From: Amanda Scholes on behalf of Planning.Responses
Sent: 15 March 2018 11:27
To: Planning Scanning
Subject: FW: 4485 - Courtwick Littlehampton - variation of conditions 4 & 24 - Ref LU/408/17/PL

Just one amendment, please -- the spacing between the gates needs to be increased to 2.0m to ensure there is sufficient manoeuvring space between the barriers for mobility scooters and wheelchairs etc. Although I have only shown one gate amended, the corresponding one will also need to be lengthened (This also follows Sustrans guidance for such matters). The arrangement shown on the original is too tight:

Drawing Number				Rev.
4485/314				E

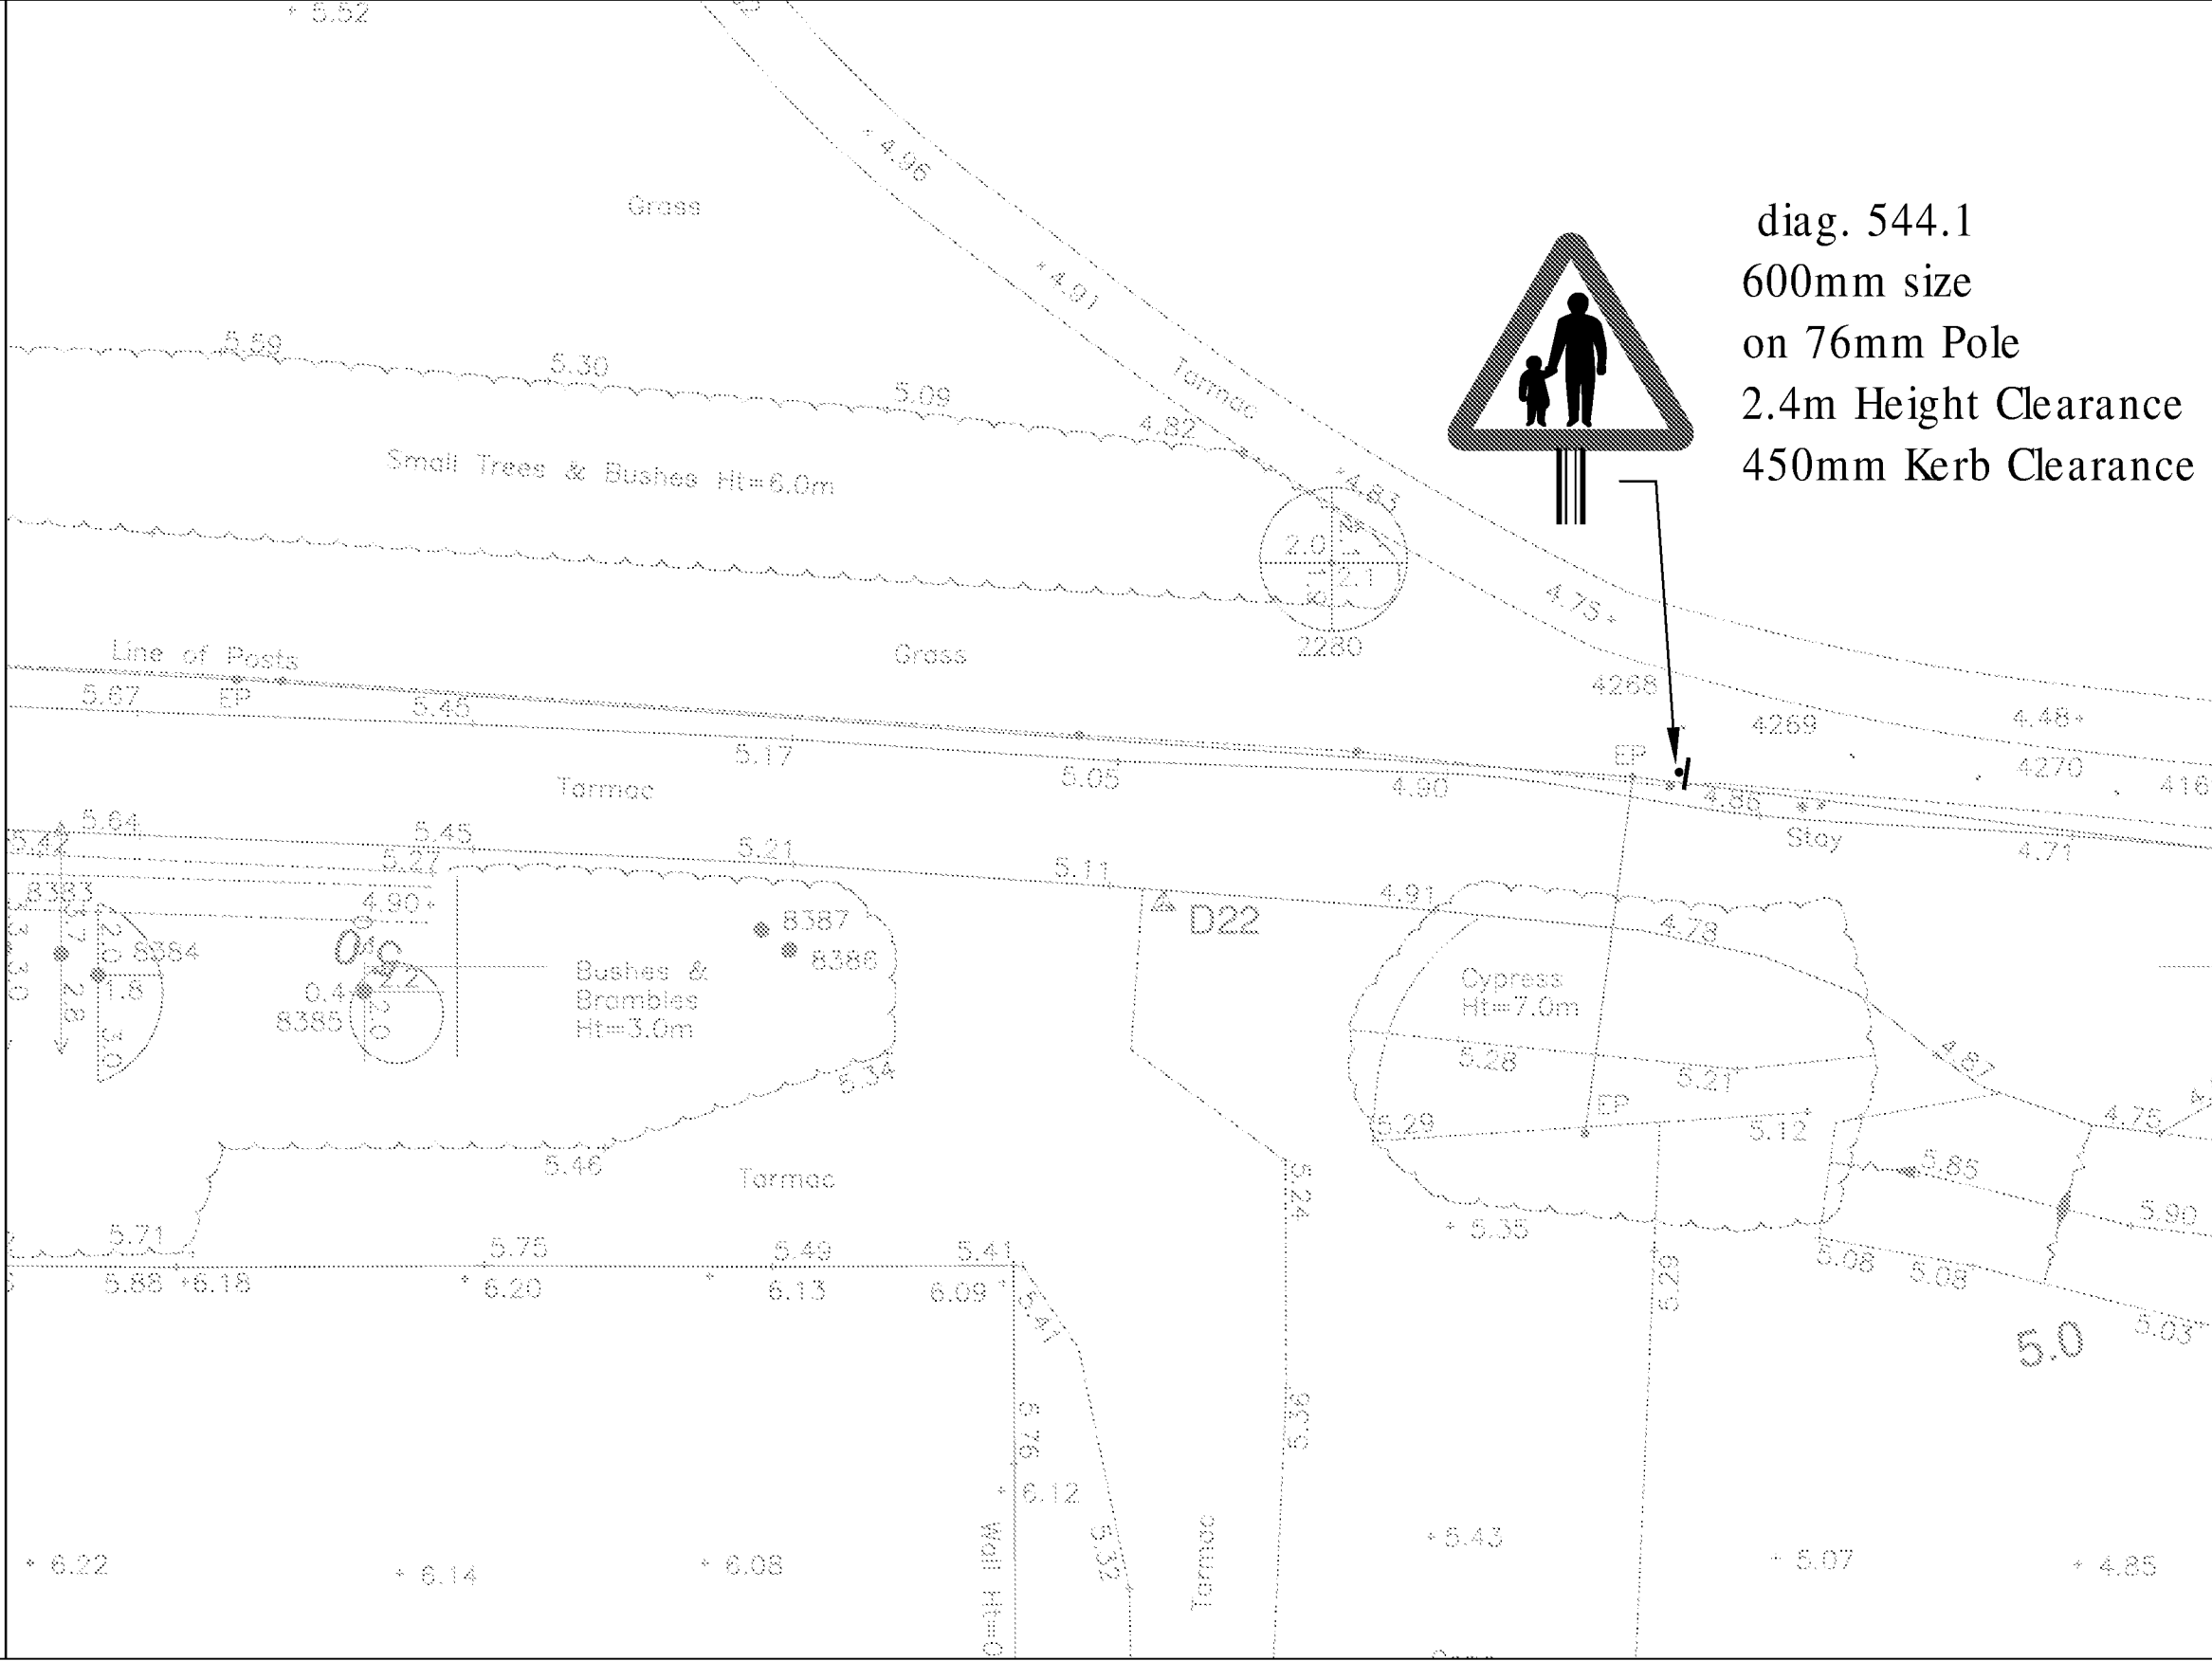
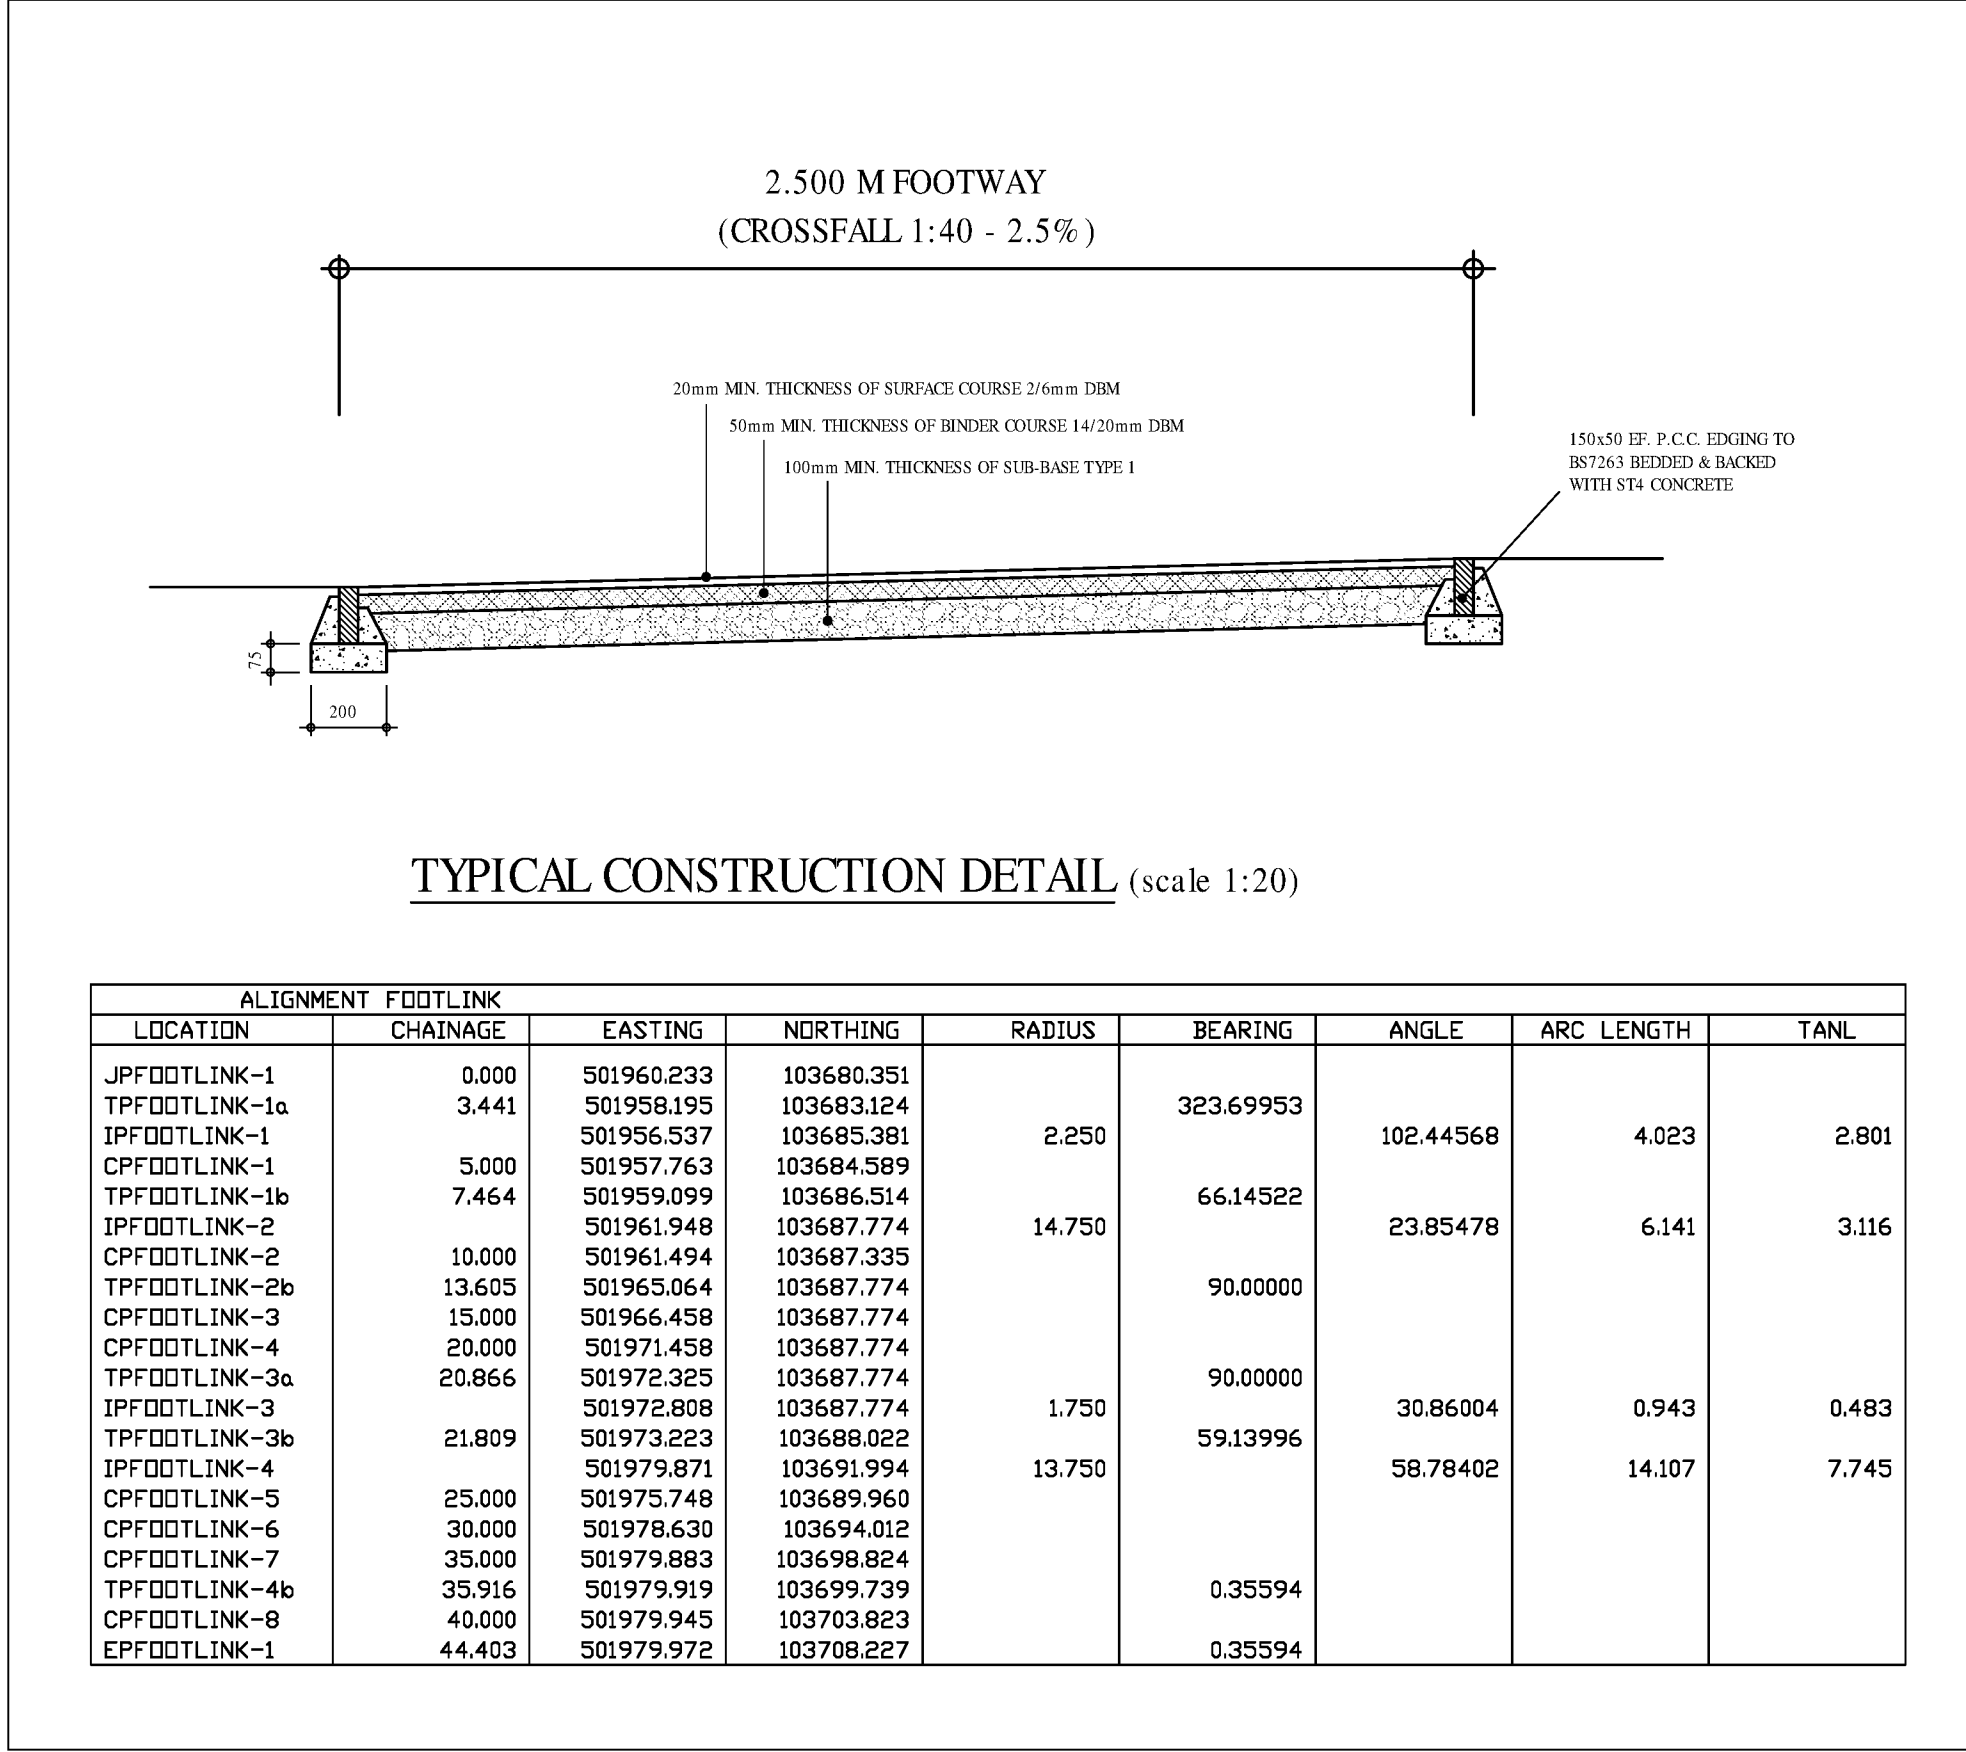
Also, I am taking it that the barrier will NOT be of the 'hooped-type' as originally proposed and of a type that prevents children from getting underneath (as shown in per one of my earlier emails)?

Further to Tim's additional comments, please find attached the updated Footpath Layout with adjusted barriers and additional notes regarding supplemental planting (tba on site).

The 'Sustrans' guidance does not provide a specification for non-cyclist barriers and the former was taken from the 'paths for all' guidance with a recommended spacing of 3m – though from 'Sustrans', this is acceptable for cycle use. I have reduced the spacing to 1.5m and have also provided a tracking diagram for a mobility scooter which confirms that this spacing should be acceptable.
